Town & Country Planning Act 1990 (as amended)
Town and Country Planning (Development Management Procedure) (England) Order 2015
Approval of details reserved by condition imposed under reference Y/92/17/OUT relating to Condition
Nos 9 - surface water drainage, 10 - maintenance & management of surface water drainage, 11 -
updated copy of management manual and 27 levels.
Land East of Drove Lane Yapton BN18 0EB

Arun District Council have decided to **REFUSE details reserved by condition for the following reasons:**

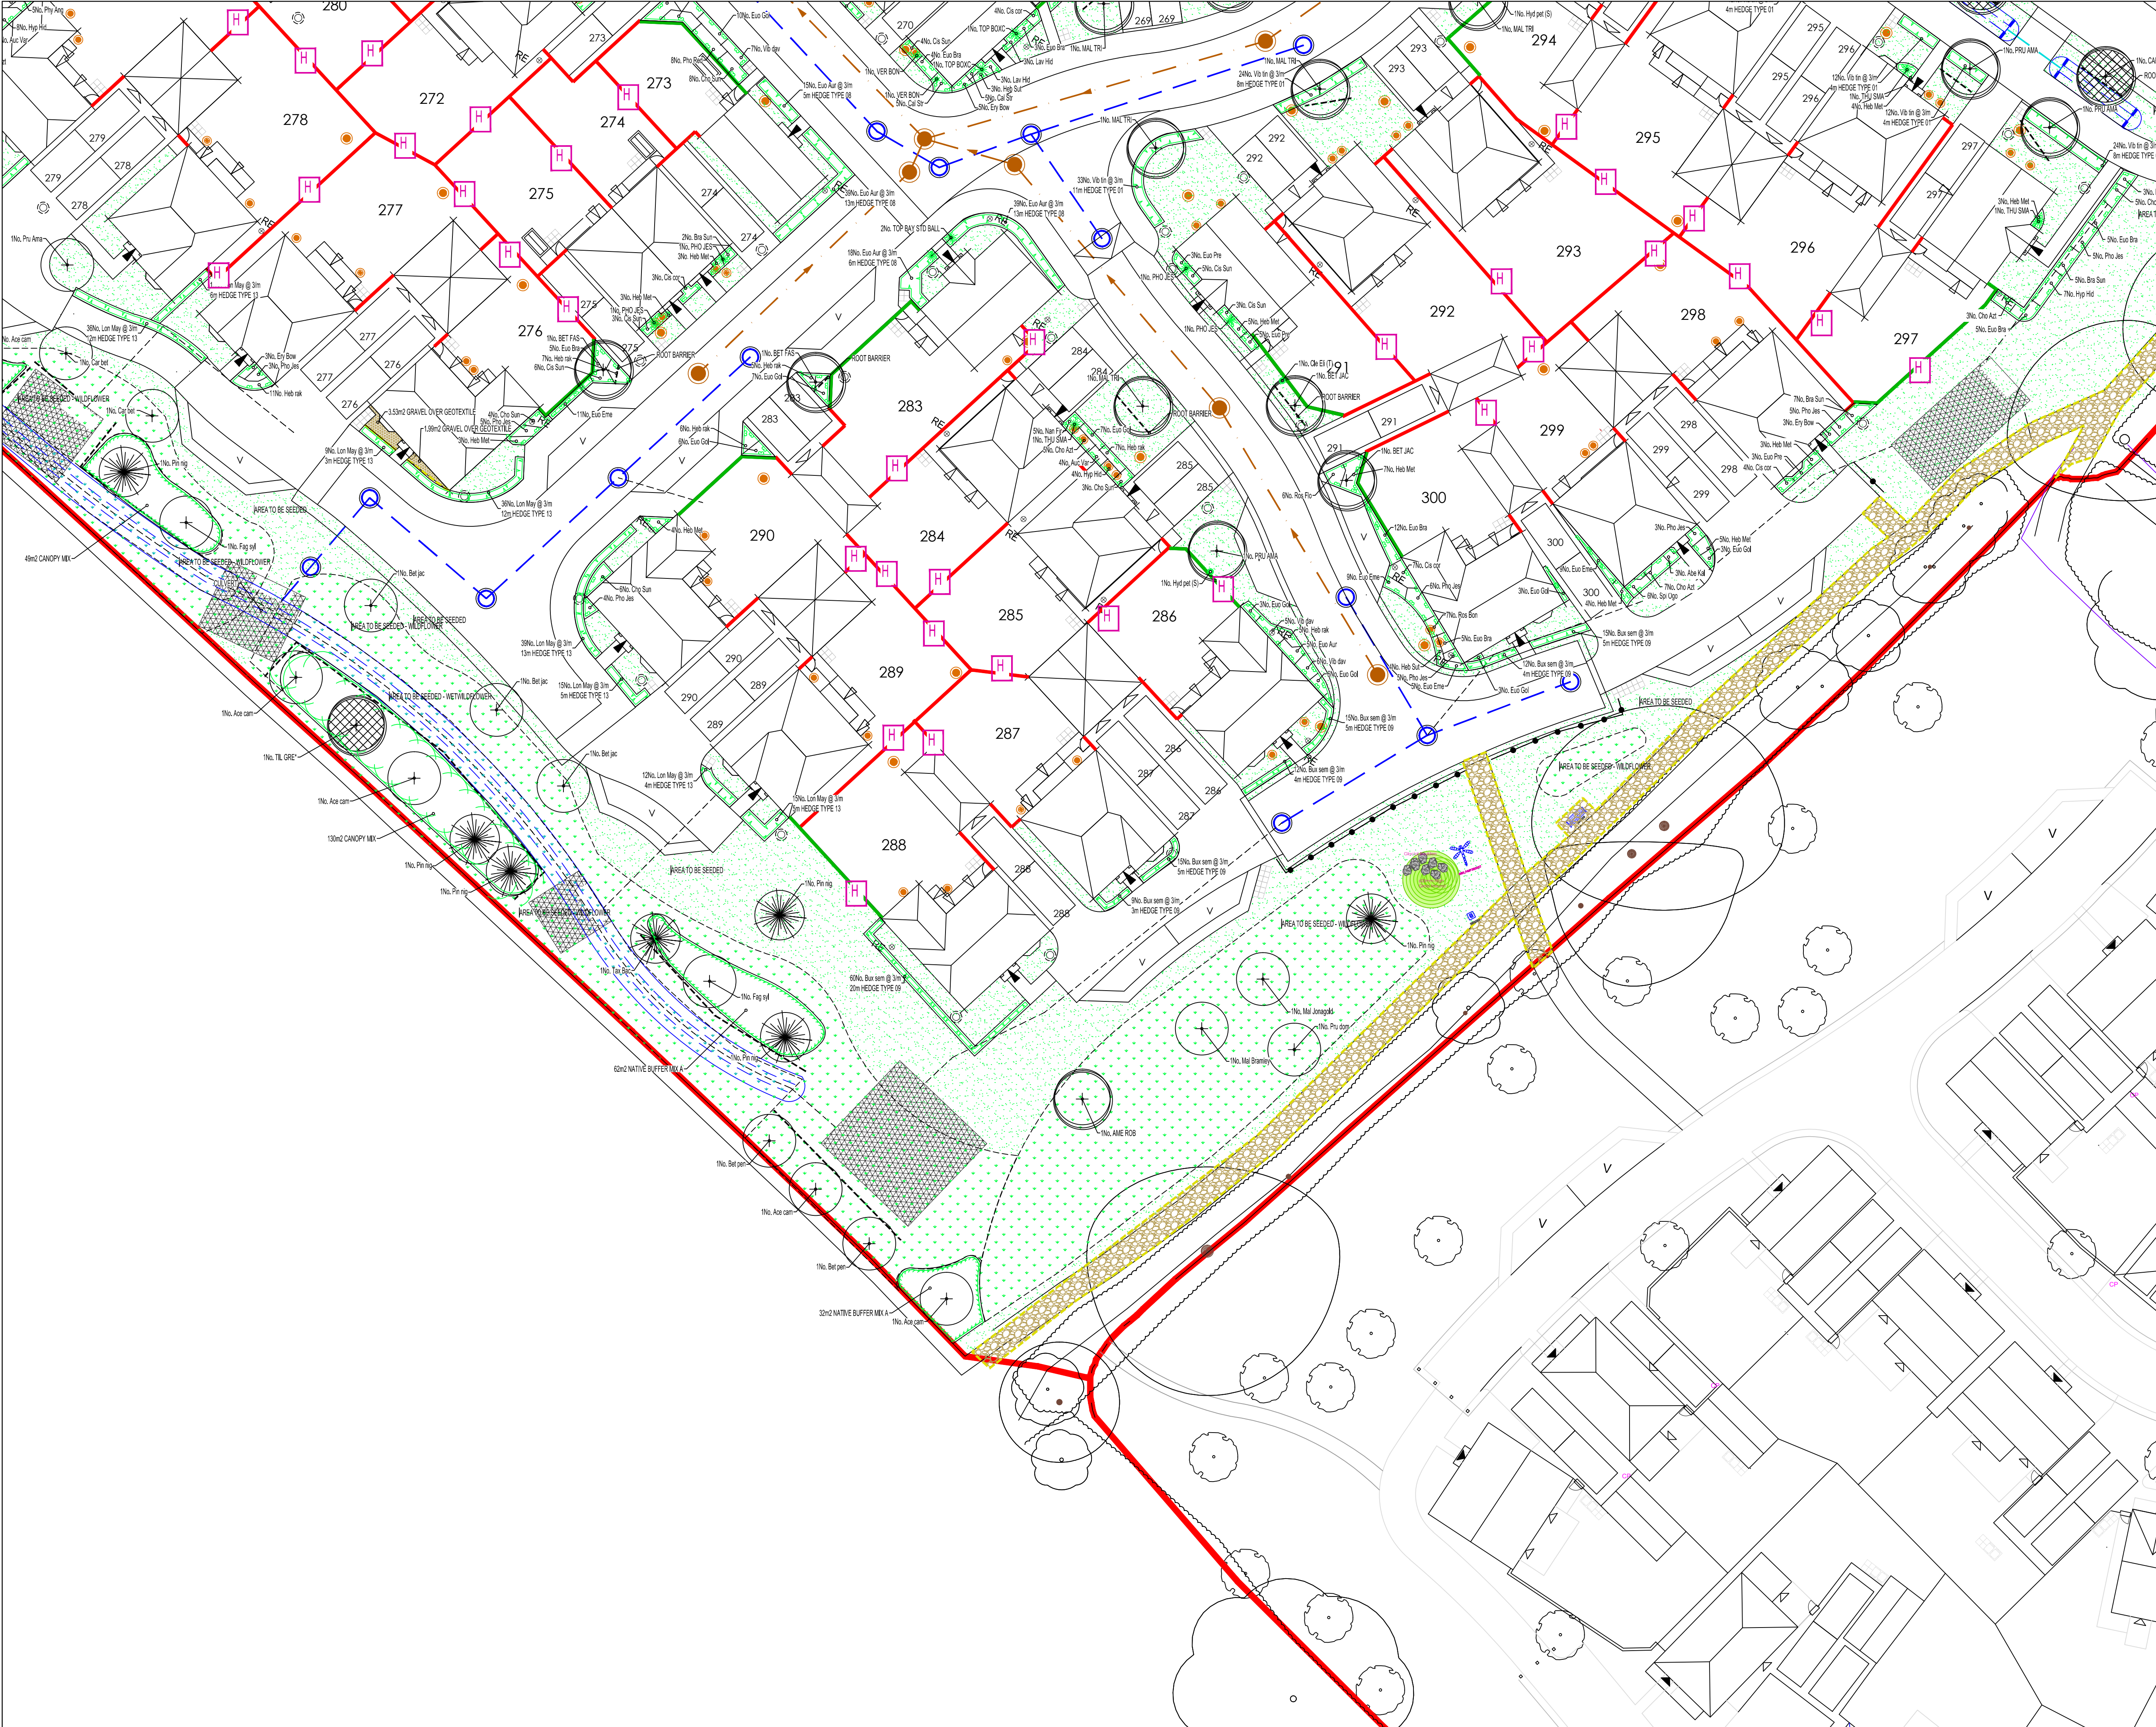
This condition cannot be discharged at the current time as you have not provided sufficient information to respond to the Drainage Engineer's initial concerns. It is noted that landscaping plans showing drainage features and Root Potential Areas had been requested but those that were provided did not have the root potential areas marked on or adequately indicate drainage features. Furthermore, additional root barriers have been indicated despite Engineers advising that these are not generally supported. Such barriers may be accepted as a last resort only when the majority of conflicting trees have been repositioned. Please resubmit together with the requested information.
